AHA! Affordable Housing In Arundel
"Seeking to Preserve Arundel"

Monday 3rd Deecember 2018.

Re Blastreat , Fitzalan Road.

Figure 3: Layout of windows analysed at 2 Fitzalan Road, illustrative only, not to scale.

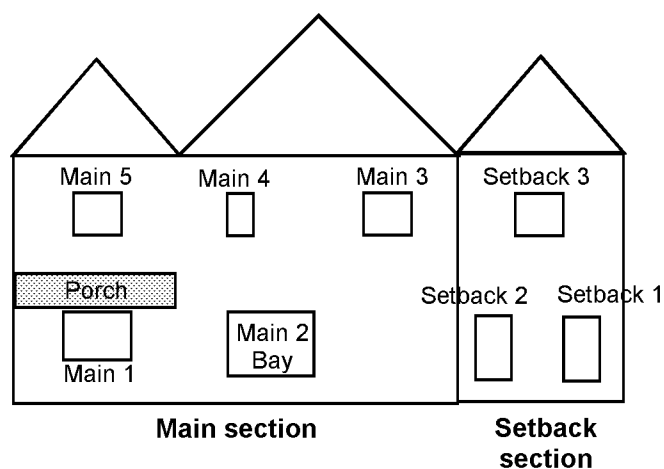
4. **Windows and rights of light and daylight:** The officers report states that the daylight assessment is acceptable. However, there remain two major errors: first, since the daylight report was conducted, the applicants have submitted new plans confirming riverside house and ottmers quay are some 600mm closer to the development site (we say they are closer than that). That means the proposed building will impact on the windows and the report was based on incorrect plans so it is not credible. Secondly, and incredibly, the daylight report still completely fails to mention or assess the nearest window in the southern gable of riverside house which is some 7m from the proposed buildings. In this regard your report is also wrong because it fails to mention this window, states the nearest window is about 4m farther away than it is and states that the applicants daylight report is correct- which it obviously is not. Will you now correct it please?
